Our Case Number: ABP-318573-23

Re: A proposed Road Development comprising of the N2 Slane By-Pass and Public Realm Enhancement Scheme
Within the Townlands of Slane, County Meath

Our Ref: SID-MH-2023-42

N2 Slane Bypass and Public Realm Enhancement Scheme

Project
**N2 SLANE BYPASS AND
PUBLIC REALM ENHANCEMENT SCHEME**

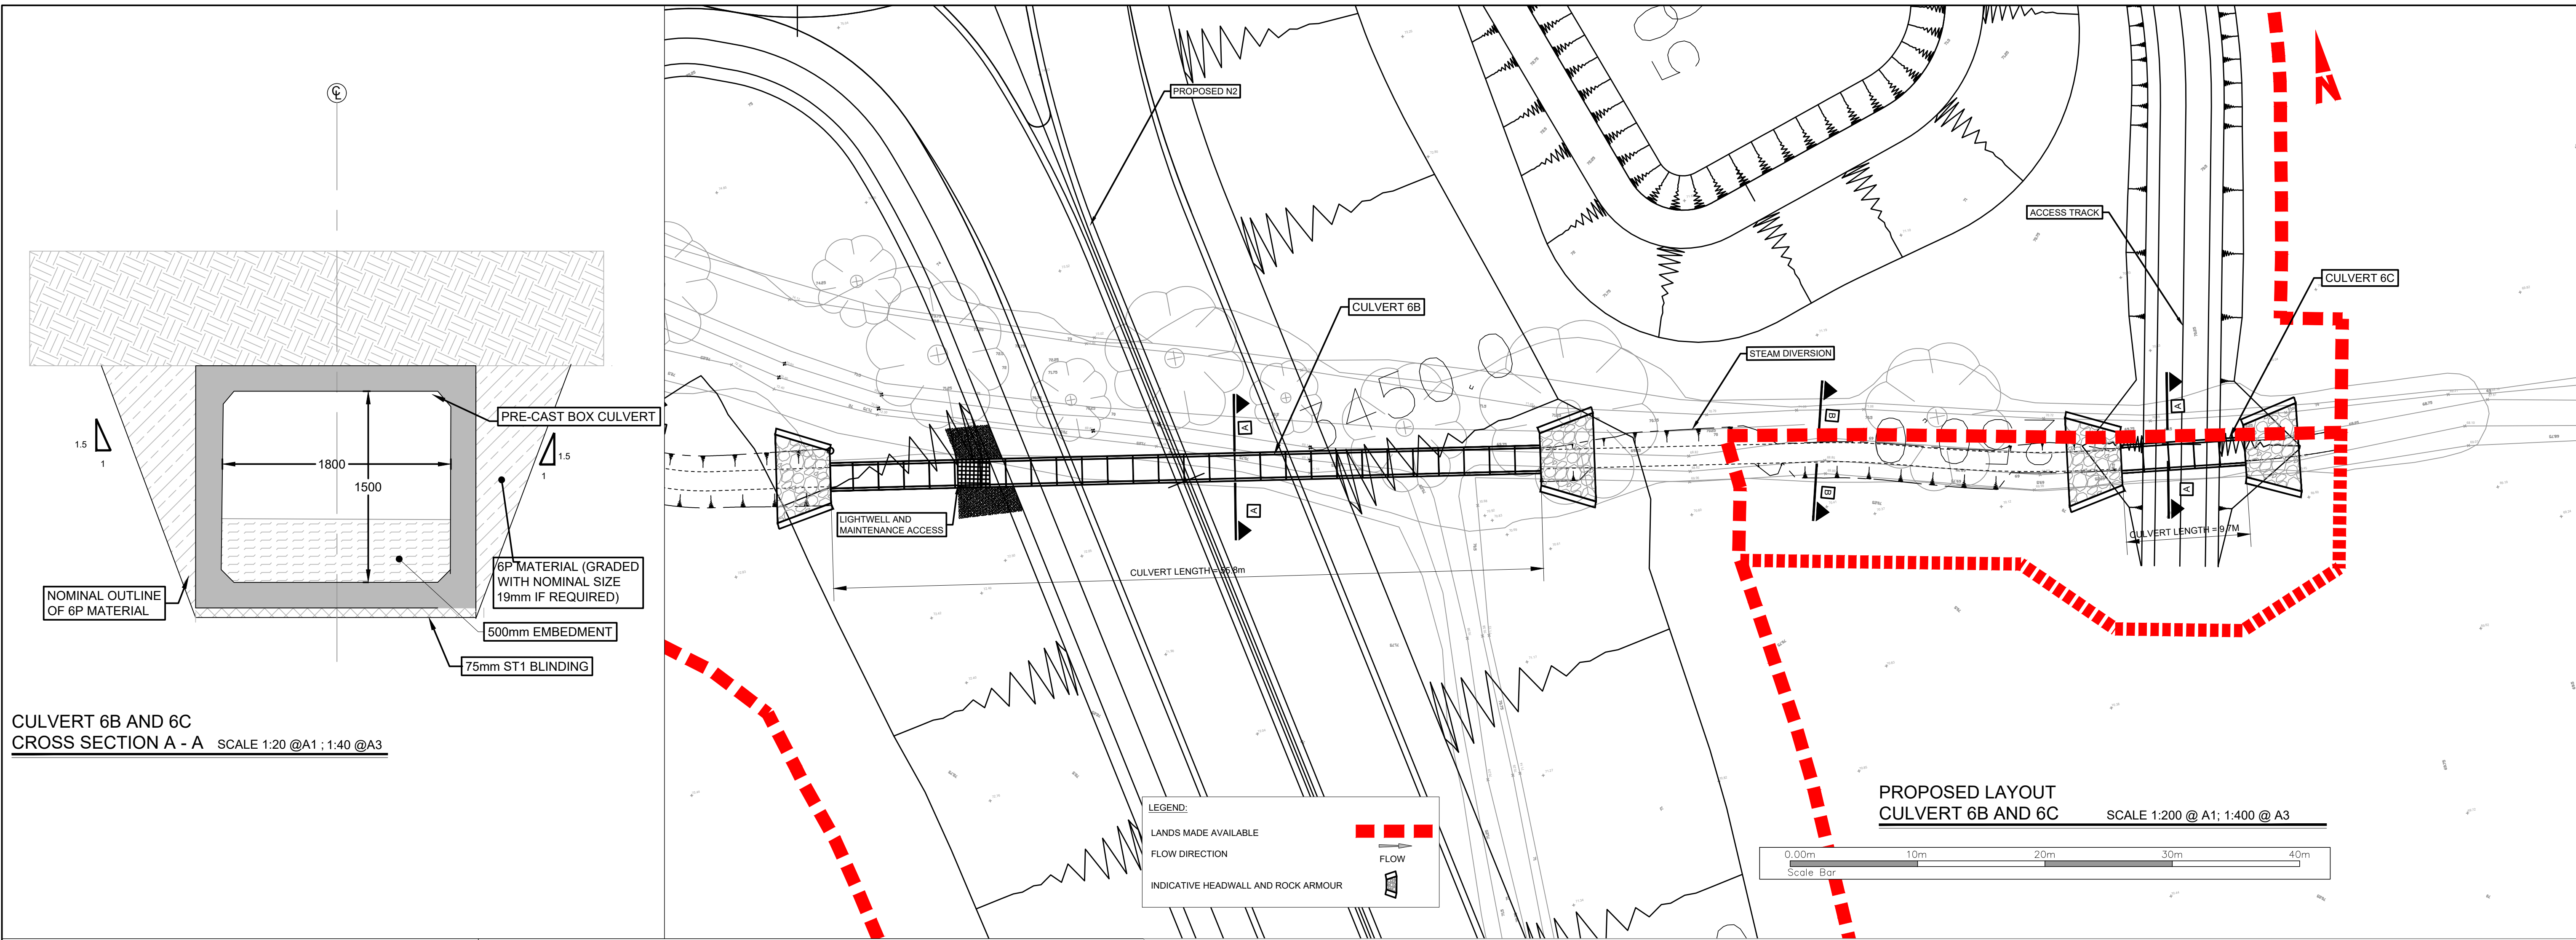
This Department notes that construction of the northern tie-in to the N2 will require construction of a sequence of culverts for the Mattock (Mooretown) Stream, an upper tributary of the River Mattock. A section of this watercourse is already culverted to accommodate the existing N2 road, this is existing culvert will need to be extended, in addition to the construction of new culverts (Culverts 6A–C: see EIAR Sections 5.4.7.4; 5.4.8.3; 5.12.2; 5.12.9.2). These works will require the temporary diversion of the Mattock (Mooretown) Stream and some in-stream works. The affected sections of the watercourse are in proximity to Recorded Monument ME019-013---- (Souterrain) and undesignated sites ACH12, ACH21, ACH38, ACH28 (as described in Chapter 13 of the EIAR). There is a potential for direct negative effects to underwater archaeology from culverting of the watercourse. NMS notes that this is not discussed or considered in Chapter 13 of the EIAR.

2. The developer shall commission a pre-construction Underwater Archaeological Impact Assessment (UAIA) report to include the following:
 - a. A licenced wade assessment, accompanied by a hand-held metal detection survey, centred on the area(s) where works are proposed within the Mattock (Mooretown) Stream. A Dive/Survey licence (Section 3 1987 National Monuments Act) and Detection Device consent (Section 2 1987 National Monuments Act) will be required for the wade survey and metal detection, respectively.
